Mark E. Jones, PE

July 13, 2025

Ref: Site Observations and Analysis
79 Mill Bend Dr.
Fuquay-Varina, NC
Project No: 25-037

FOUNDATION PLAN
SCALE: 1/4"=1'-0"

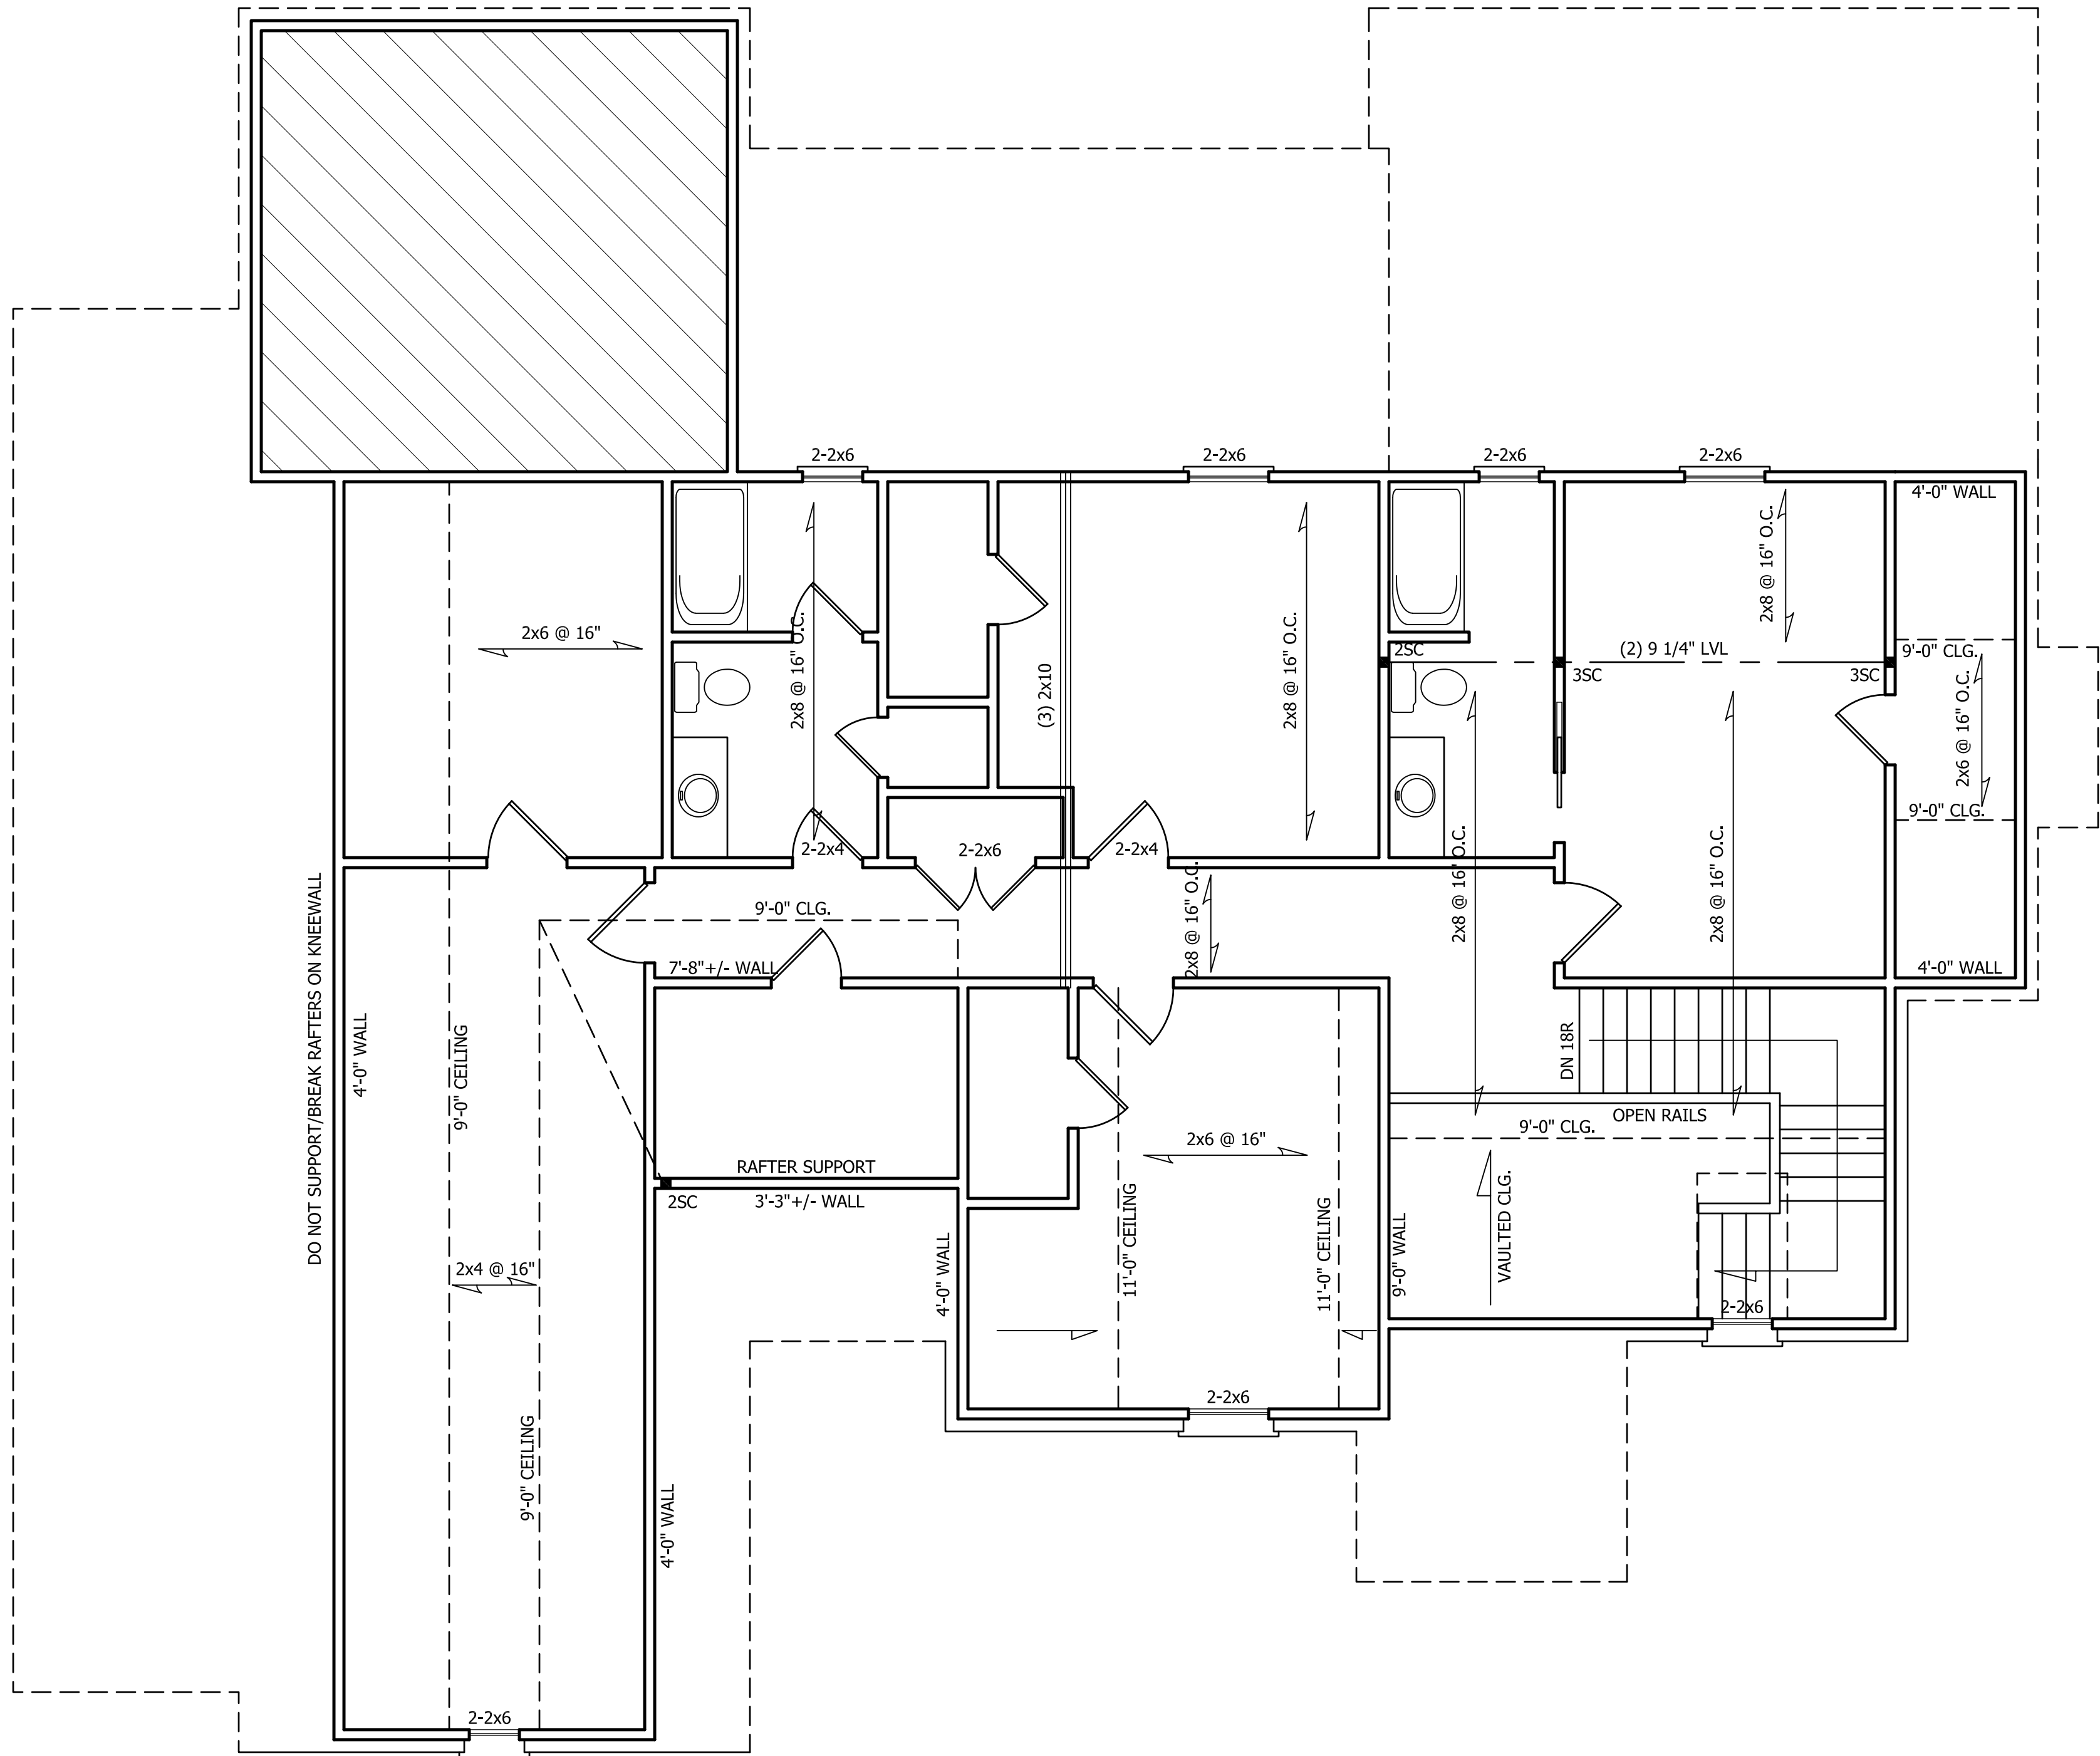
1. Engineer to evaluate allowed fill at porches.

1. The plans for the referenced house specified concrete slabs on fill for the front and rear porches. The foundations for the front and rear porches are up to 64"-67" in height from the top of the footings. All foundation walls are filled solid and 12" wide. The contractor may fill both porches with #57 stone.

Note that the contractor shall provide #4 rebar embedded in the foundation 12" and turned into the slab 24" at the exterior walls of the rear porch.
